Ribble Valley Borough Council
By email

Your ref: 3/2022/1000
Our ref: DC/22/3732
Date: 10-NOV-22

Location: Land at Neddy Lane Billington BB7 9LL

Proposal: Discharge of Condition 13 (Surface Water Drainage) from planning application 3/2021/0205

Development	BILLINGTON		
Location	NEDDY LANE		
Marketing Name	CALDER GRANGE		
Drawing Title	DRAINAGE LAYOUT		
Drawing Number	4441 / Eng / 001-3	Revision	E
Drawn By	CLB	Scale @ A1	1:500
Checked by	-	First Issue	20.04.21

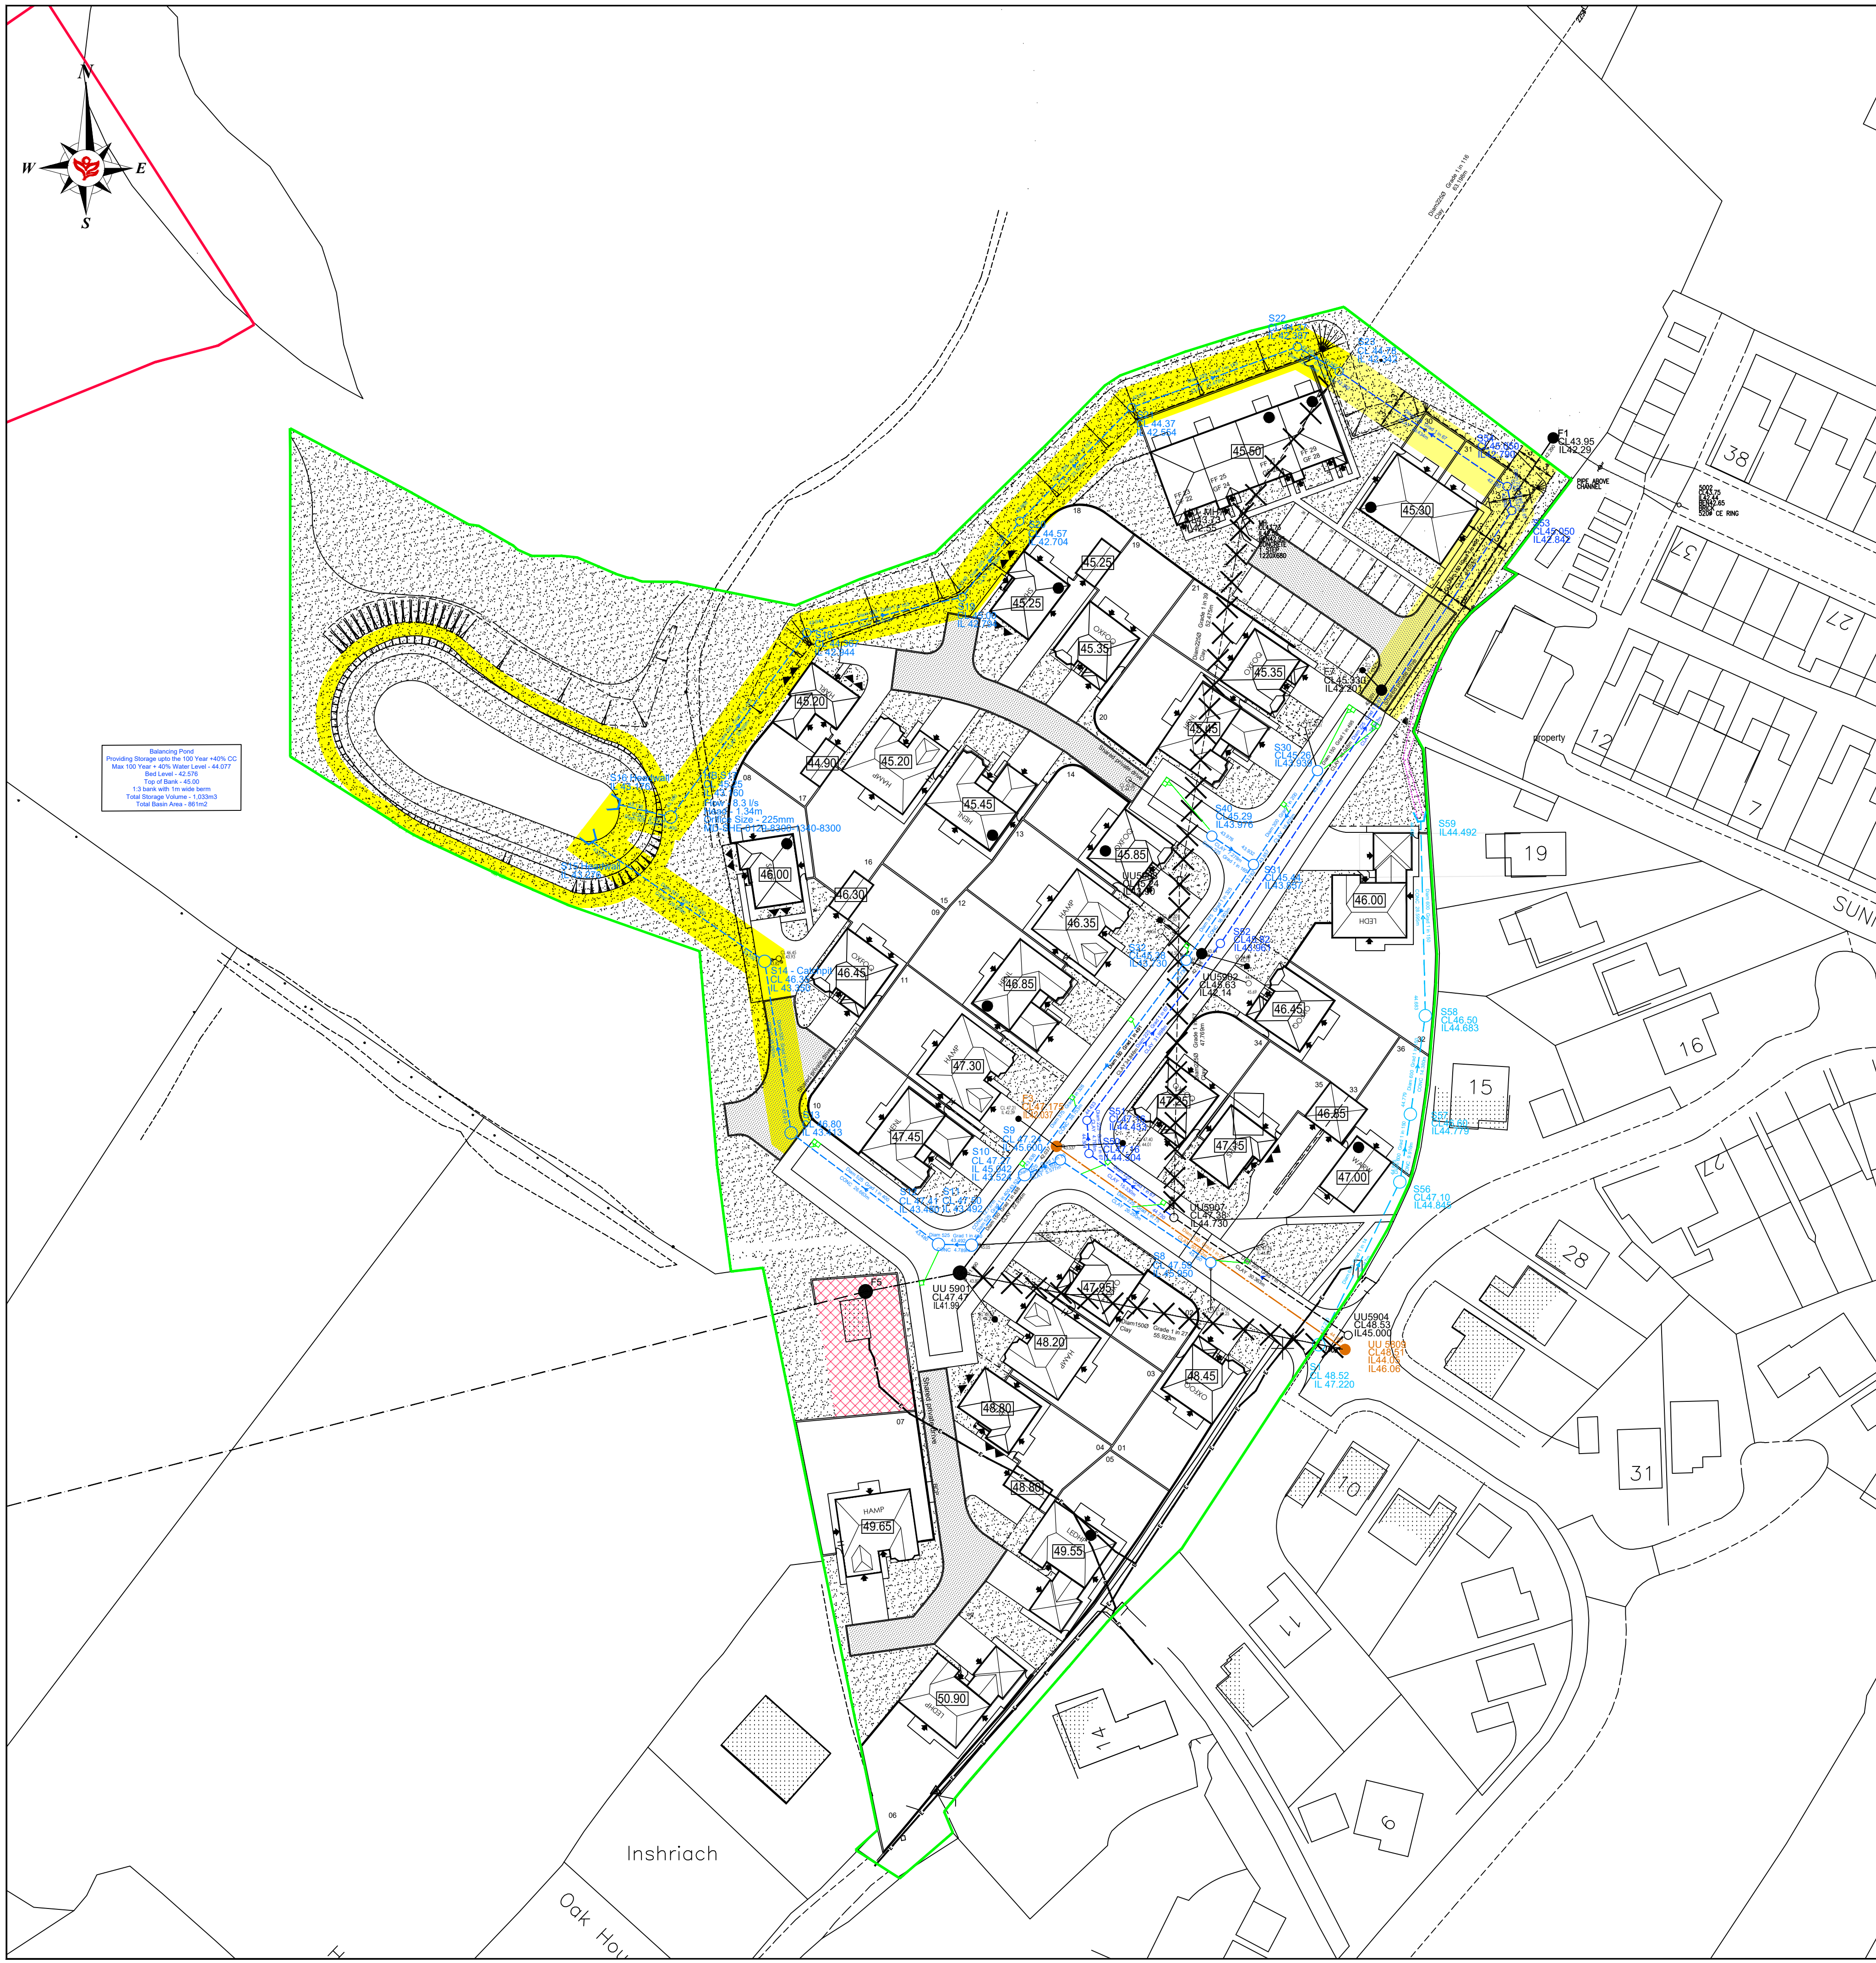
Further to our review of the submitted documents, Drawing 4441/Eng/001-3, Rev E - Dated 30/06/22, United Utilities recommends that condition 13 is not discharged.

1. The applicant must demonstrate agreements with United Utilities to abandon and clear the sewer assets in the submission. It must be understood by the applicant and the LPA that the details of the abandoned assets and diversions have not been agreed. We strongly recommend the detail required for condition 17 of 3/2021/0205 is agreed alongside discharging condition 13 as they are intrinsically linked;
2. Please review the Finished Floor Levels (FFL) against some of the cover levels of proposed sewers in the site. It is noted that the FFL are lower at properties at the site entrance than the cover level at the existing United Utilities Foul Sewer manhole (UU 5509). Attention also need to be given to manhole S11; and
3. Proposed sewers should not be within residential boundaries. Please review and amend to move any proposed drainage features outside residential curtilage.

We notice that the proposal incorporates a SuDS component(s) which interacts with a sewer network that may be offered for adoption by United Utilities. We recommend the applicant seeks further advice regarding the SuDS design by visiting our website. See Contacts section below.

If the applicant intends to offer the site drainage forward for adoption to United Utilities, they should be aware that the proposals submitted within this application **do not** currently meet with our adoptions criteria. We recommend the applicant seeks further advice regarding the SuDS design by visiting our website. See Contacts section below.
